Application Reference: 2026/0137

Site Address: 2 Oaks Farm Drive, Darton, Barnsley, S75 5BZ

Introduction: This application seeks full planning permission for the demolition of conservatory to side and replace with new single storey side extension, convert integral garage to habitable area, reposition of front door and install cover

Project	2 Oaks Farm Drive, Darton
Client	Mr & Mrs Bee
Title	Proposed Plans and Elevations
Number	26002-DR-A-2001
Scale	As indicated@A3
Revision	C
Description	Updated to suit planning comments.
Stage	Building Regulations
Drawn	TD
Date	04.06.2026

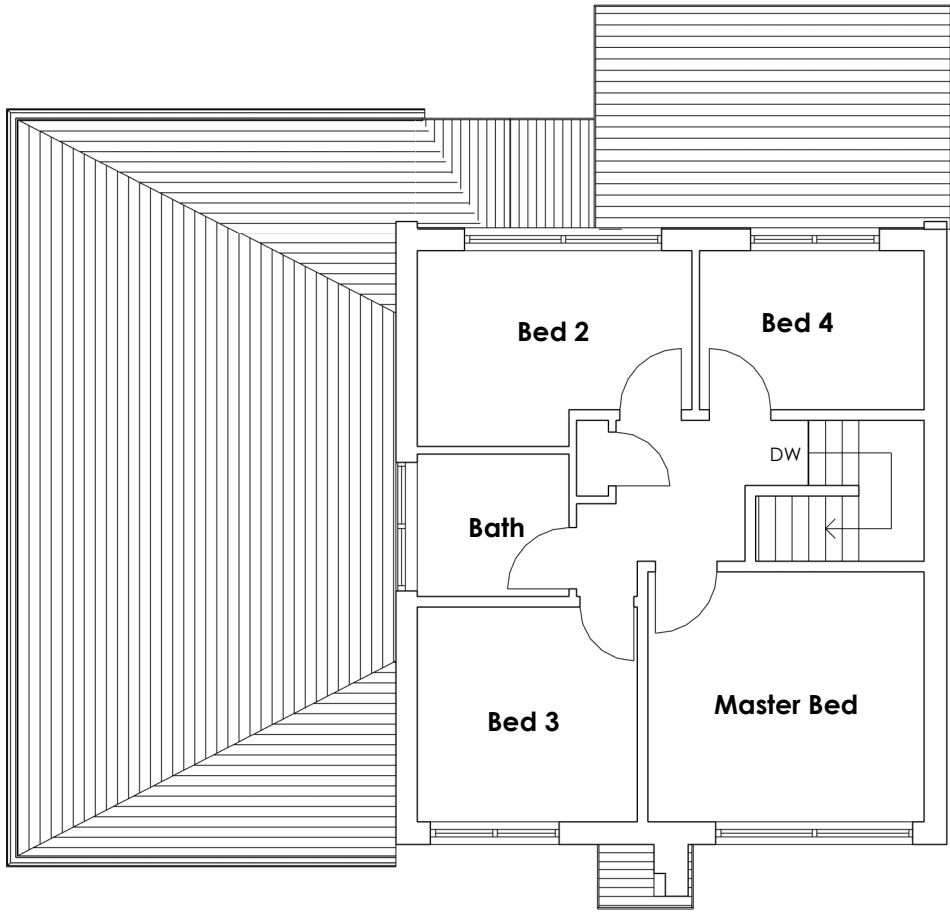
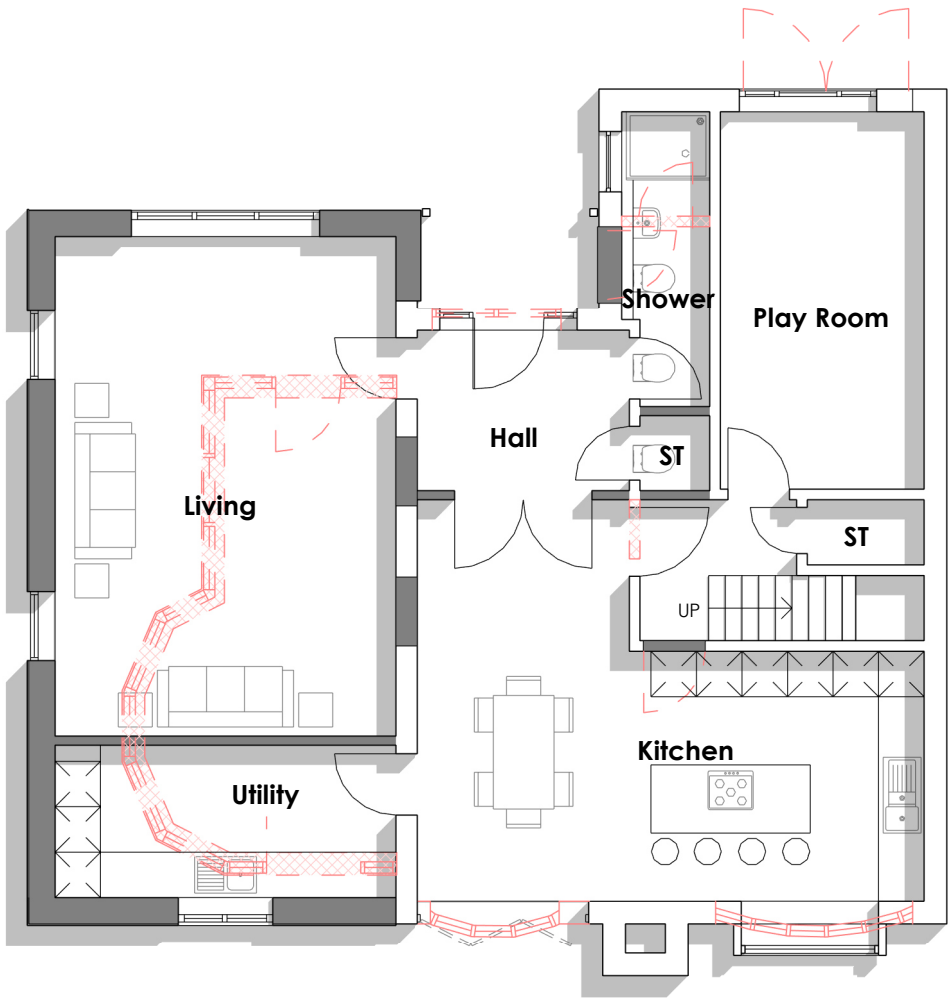
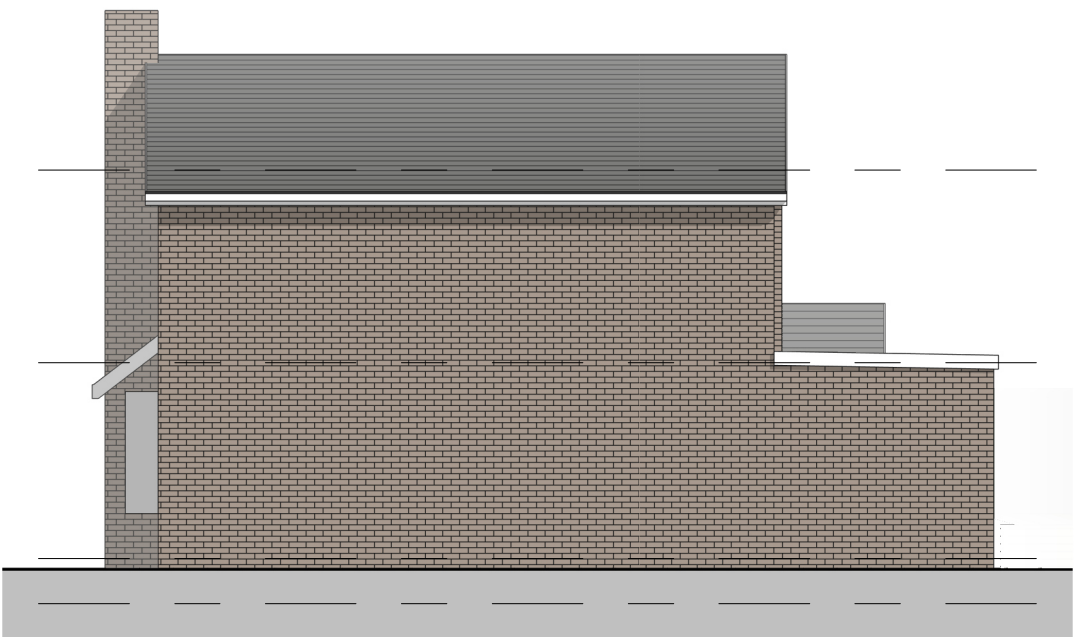
The proposed extension is reasonably large with a footprint of around 47 sqm, but this is mitigated by firstly the removal of the conservatory it replaces, reducing the net scale of the extension to approximately 27 sqm. Secondly, with the proposed roof being a mono pitched, only small portion of it adjacent to the house, at an approximate height of 3.74m would be higher than the approximate 3.48m maximum height of the existing conservatory.

With the conservatory located on the side elevation of the dwelling, away from the adjacent neighbouring dwelling, and shielded by an established large hedge, and large trees, whilst the revised design of the front elevation sits well within the street scene, the out of character rendering to the side and rear elevations of the extension would not have as significant impact on the visual amenity of the neighbourhood, as it may have done without the established screening. The impact on the character of the house would be more significant but with the mix of materials within the existing house, and with the replacement of a UPVC conservatory, it would realistically be considered as having a modest impact on the design and character of the dwelling.

Glazed doors are proposed on the rear elevation of the existing dwelling, replacing a window and compensating for the lost doors from the conservatory. Along with the proposed side and rear windows of the extension, there would be little harm to the character or design of the dwelling. In contrast, effort has been made with a second ground floor replacement window on the rear elevation, to maintain a square frame, but appearing to be a supersized version of one of the square windows of the dual and triple frames sets of first floor window. On this occasion the design would have a limited impact on the design and character of the dwelling, but is well screened from public view.

Returning to the extension, its impact upon the front elevation of the house would be quite limited. With matching brickwork and window style to match the existing house, along with its complementary styled window, only its proposed extent beyond the original front elevation of the dwelling would be of limited concern. However, the extension remains considerably set back from the original garage, whilst the proposed porch/canopy supports infilling a gap between the extension and garage, tying them together.

The side extension itself, and the inclusion of two windows on the side elevation would have no impact to any dwellings to the side, as there are not any, and there is sufficient distance of between 9 -10m between the rear elevation of the extension and the rear boundary treatment. The proposed glazed doors and replacement window may still qualify for installation through permitted development, as the large window probably retains enough design characteristic of the original windows to be considered of similar appearance.

The proposal causes the loss of an integral garage but as shown on the proposed plans, two parking spaces of just under the required 2.5m by 5m each are indicated but having checked, there is ample space around the indicated parking spaces to accommodate the required size standards. With no other alterations to access, there would be no impact on Highway Safety.

- Too much render was initially proposed for the dwelling, covering the whole extension and the ground floor of the front elevation. The render has now been reduced to the side and rear elevation of the extension, with original yellow stone accents remaining.
- A detached garage was proposed in front of the principal front elevation of the dwelling. This would have not been in accordance with local policy guidance outlined in the SPD House Extensions and Other Domestic Extensions, or allowable through permitted development. The garage has since been removed from the proposal.
